Fire Department

MEMORANDUM

7 October 2009

Re: 645 Congress Street

NOT FOR CONSTRUCTION

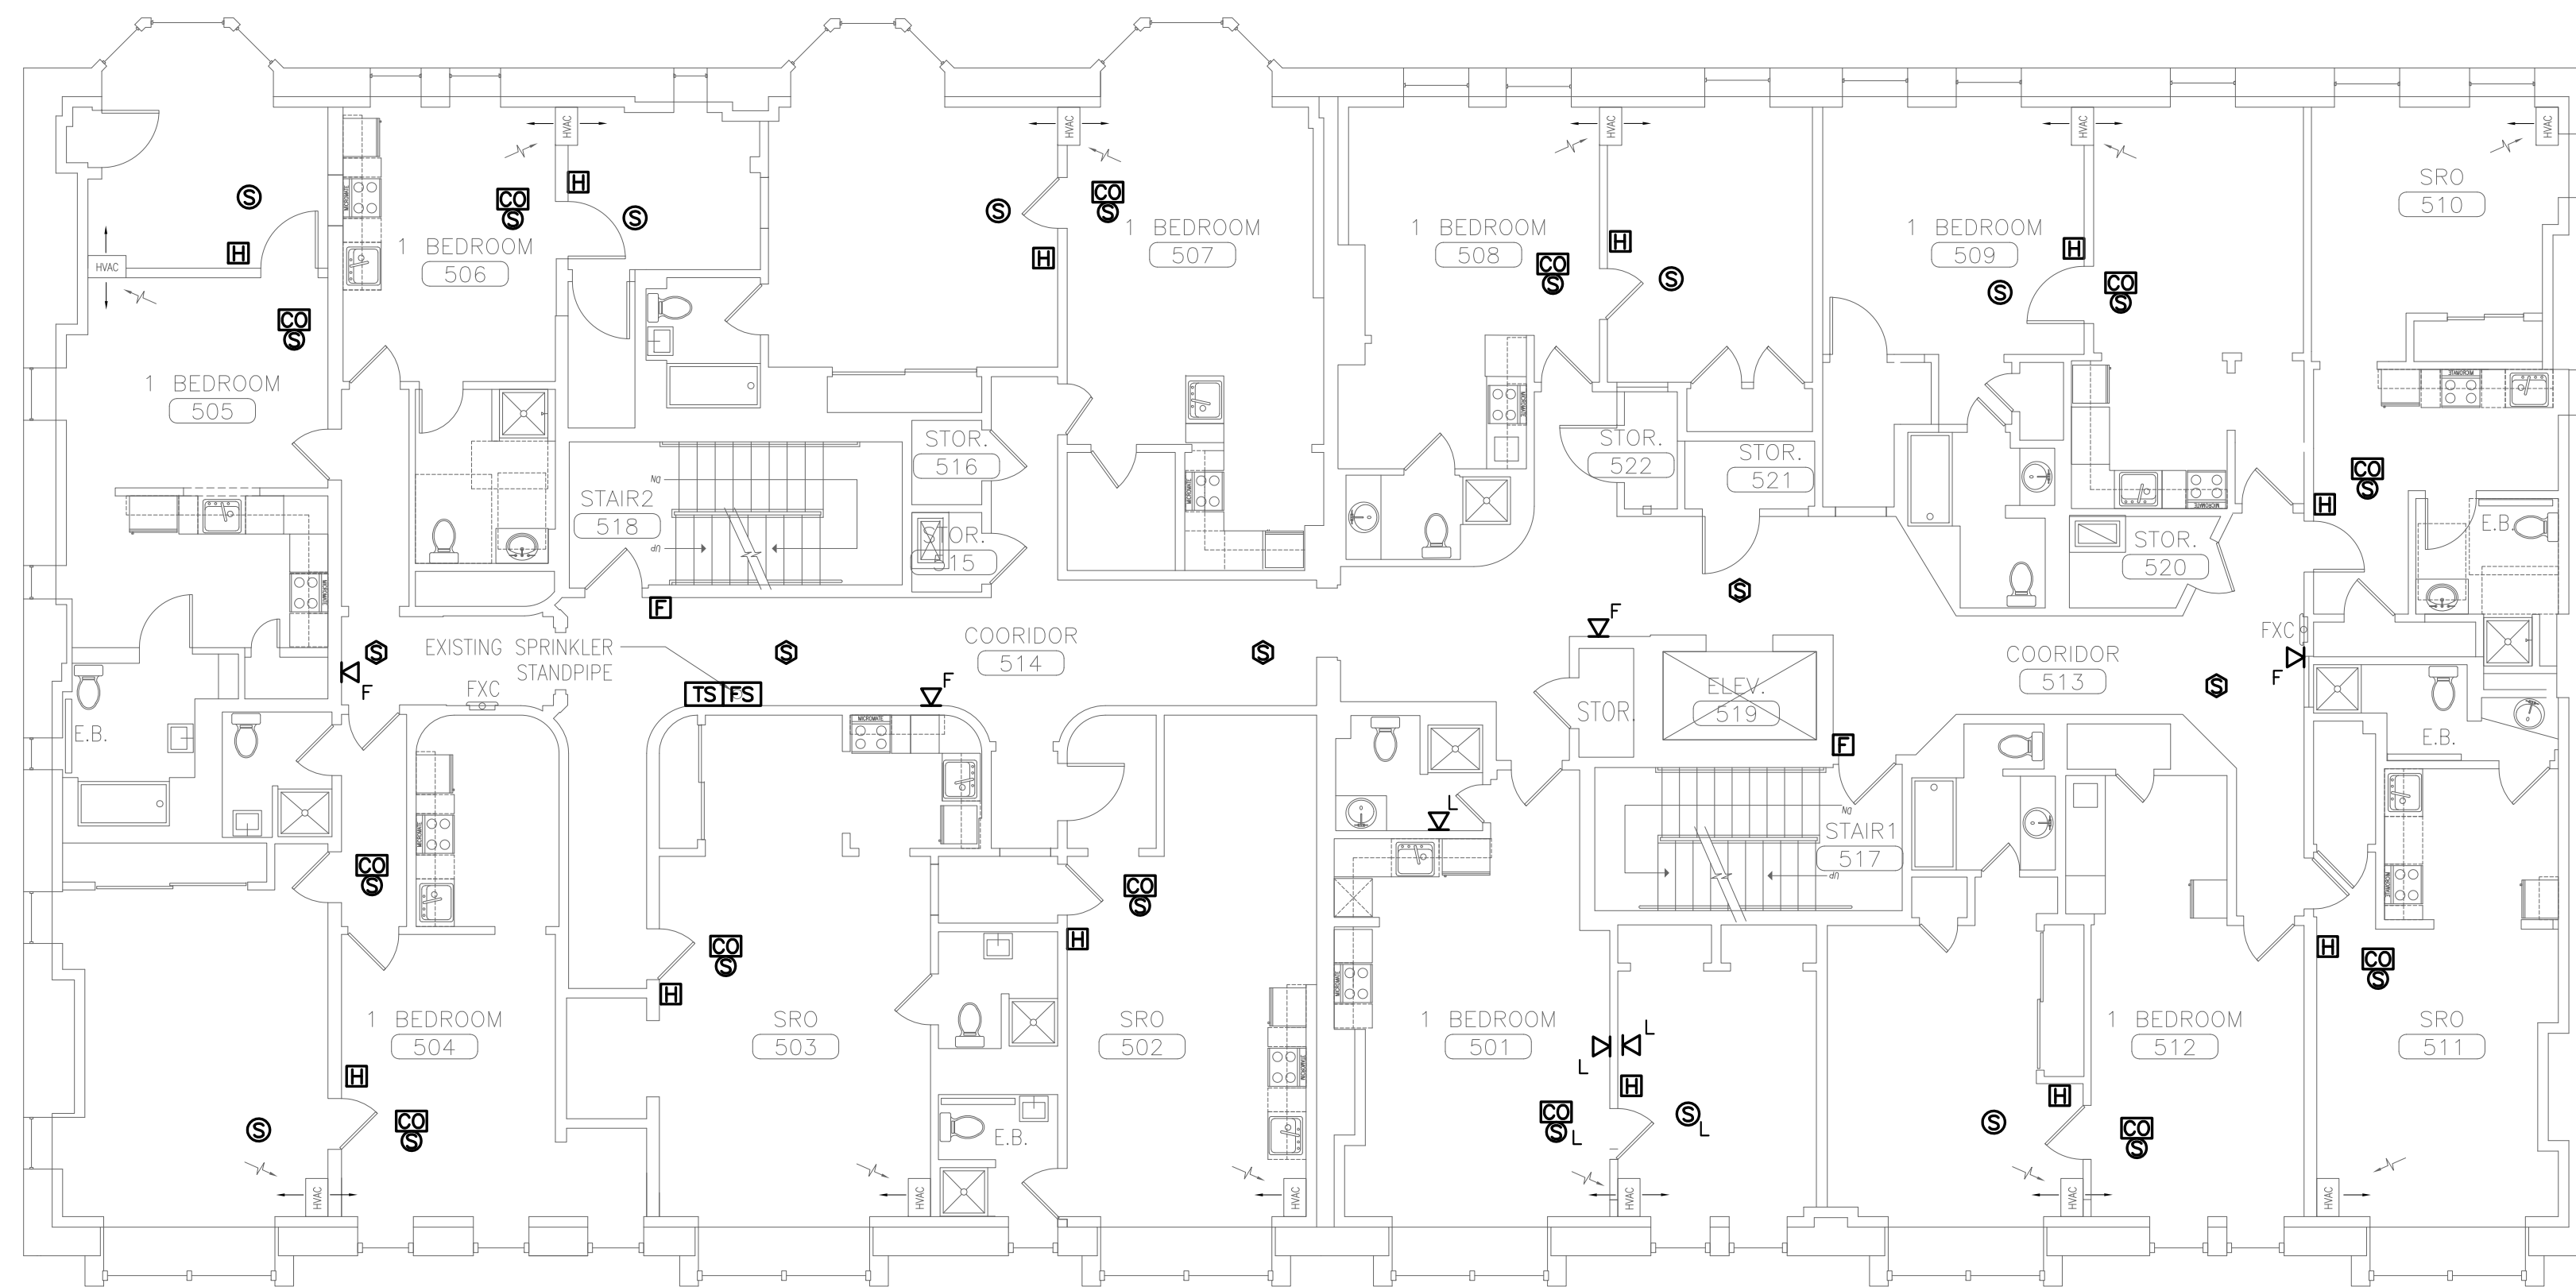
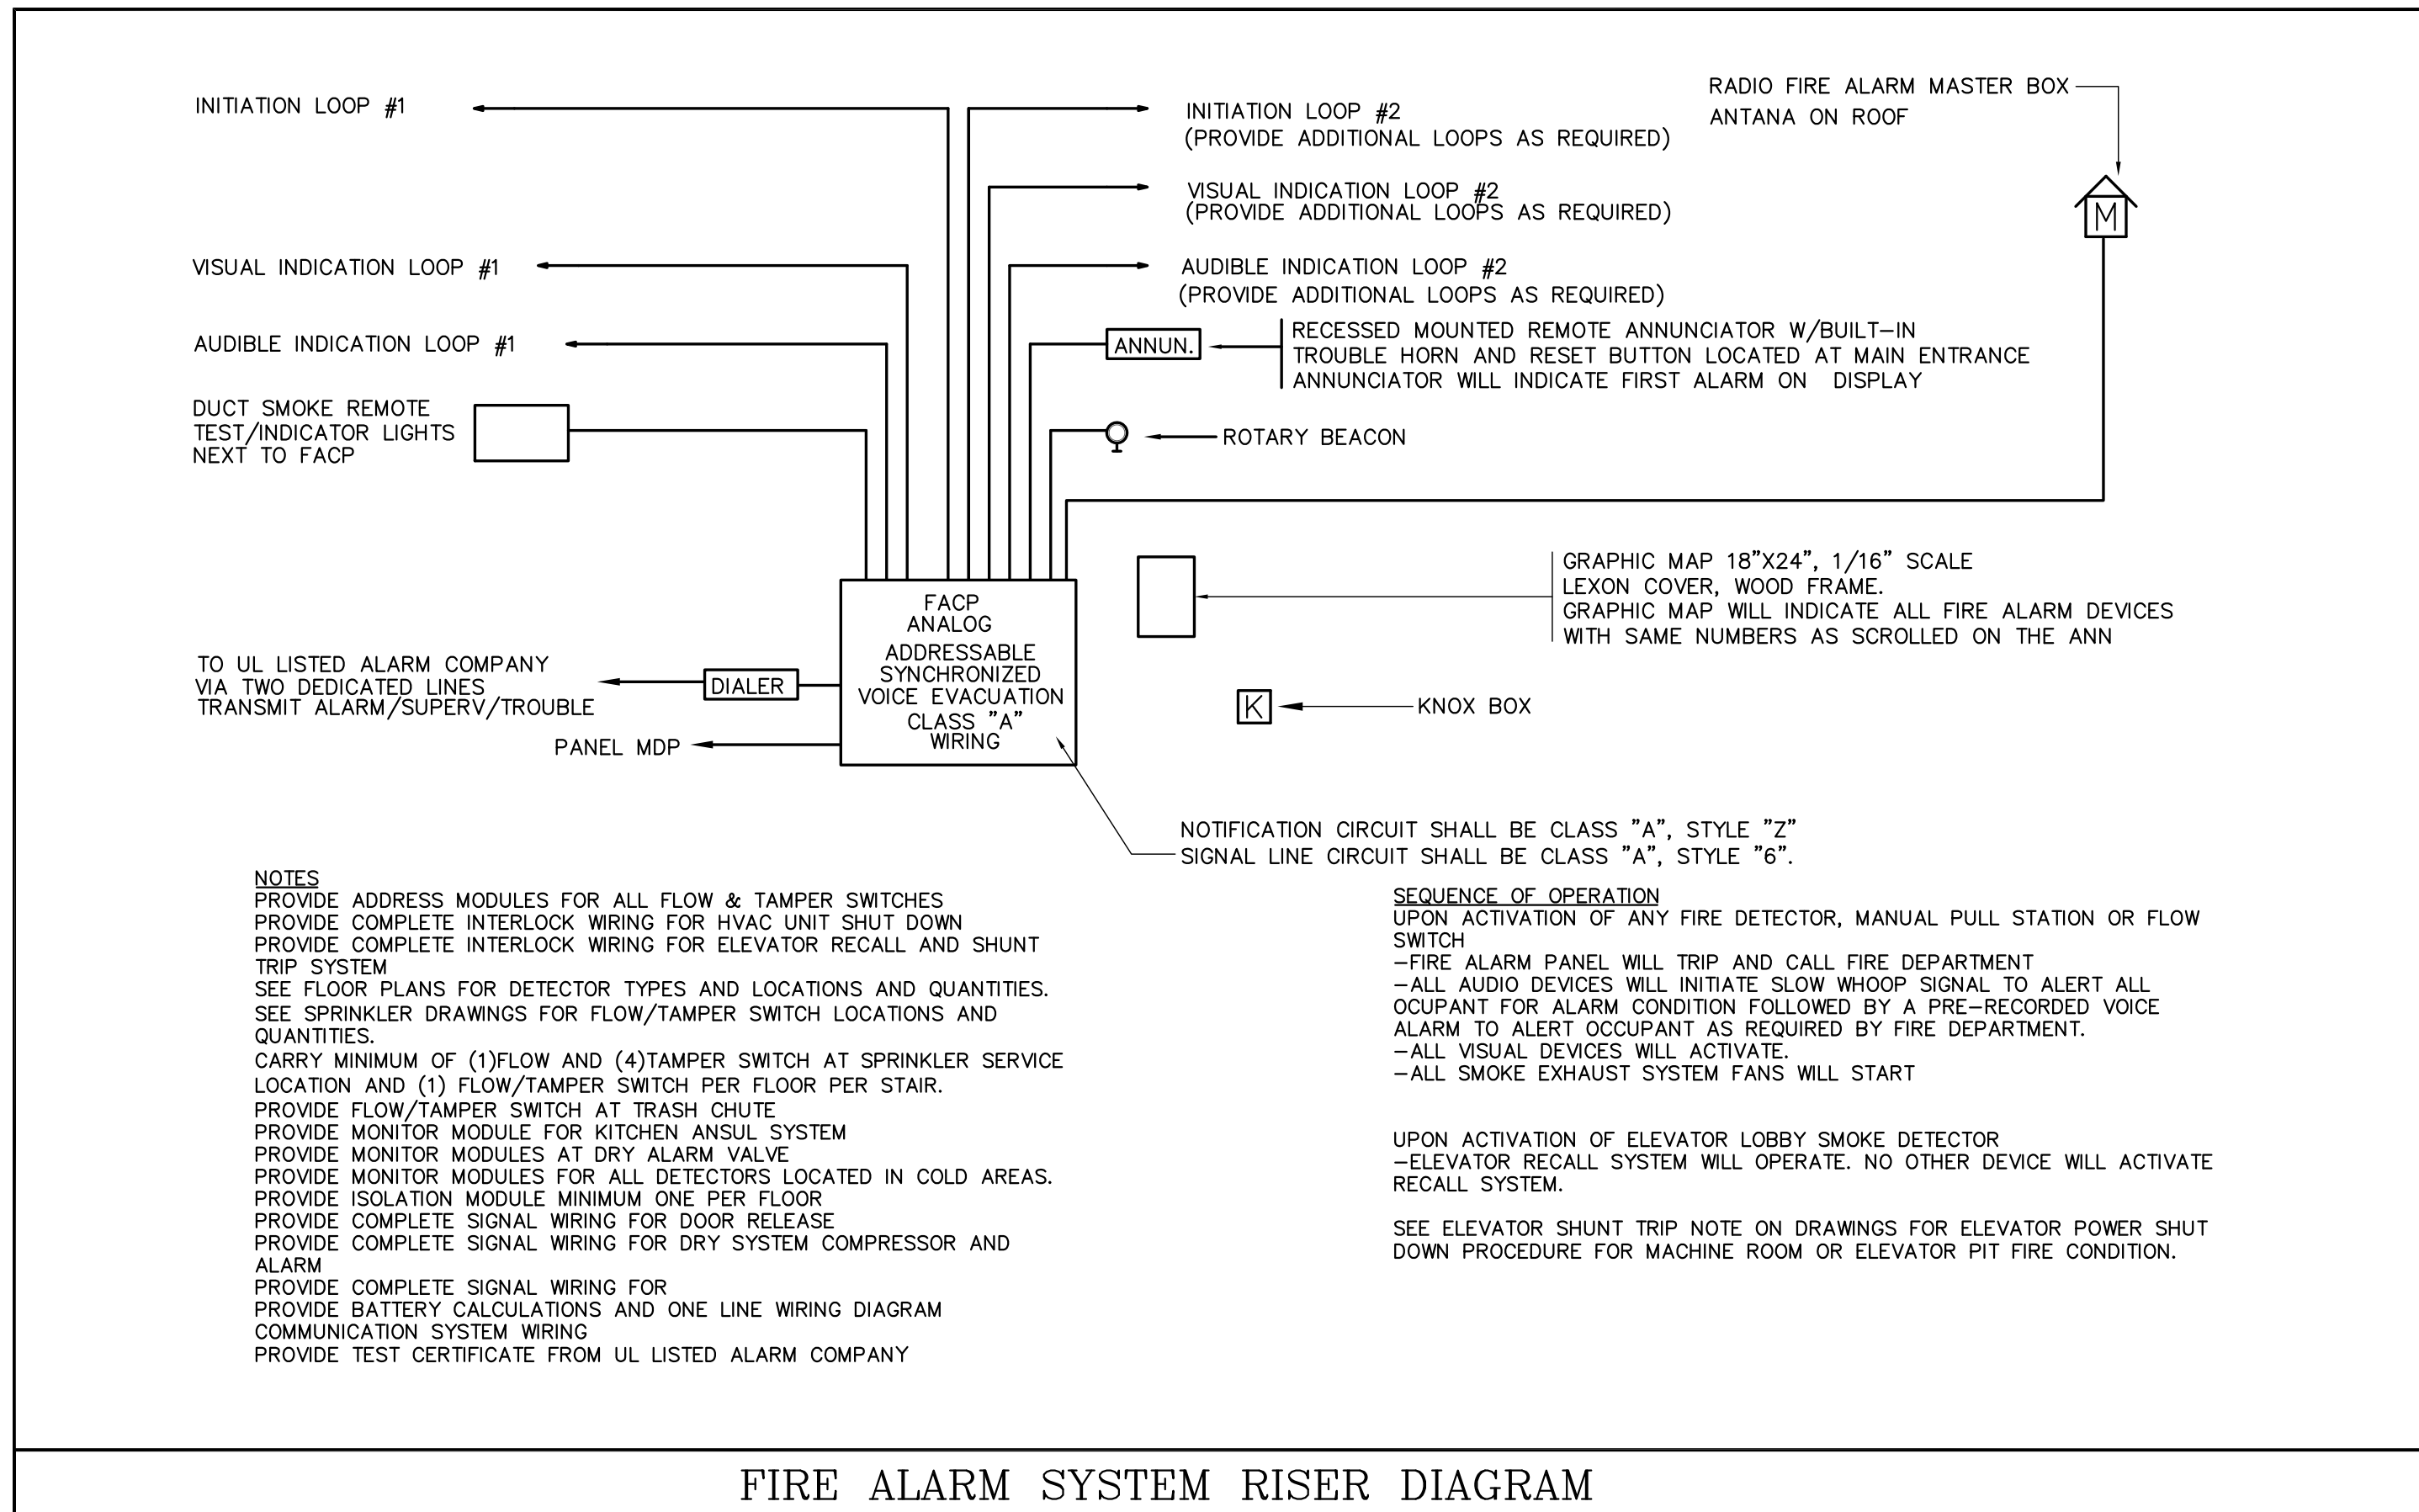
1. Because of the reuse of the existing building, certain existing fire alarm cable may be reused. All such cable shall be Fire Power Limited Plenum (FPLP).

2. In rooms where ceilings are sealed or the space above the ceiling is combustibile, all such cable shall comply with the National Fire Alarm Code, Article 760 of the National Electrical Code (NEC) and current City Code.

3. Where wiring is added or replaced, it shall comply with the National Fire Alarm Code, Article 760 of the National Electrical Code (NEC), and current City Code.

4. It must be verified there is two notification circuits on each floor, providing that every other notification appliance is on a different circuit.
5. An inspection of all fire alarm cables shall be performed prior to any close-in.
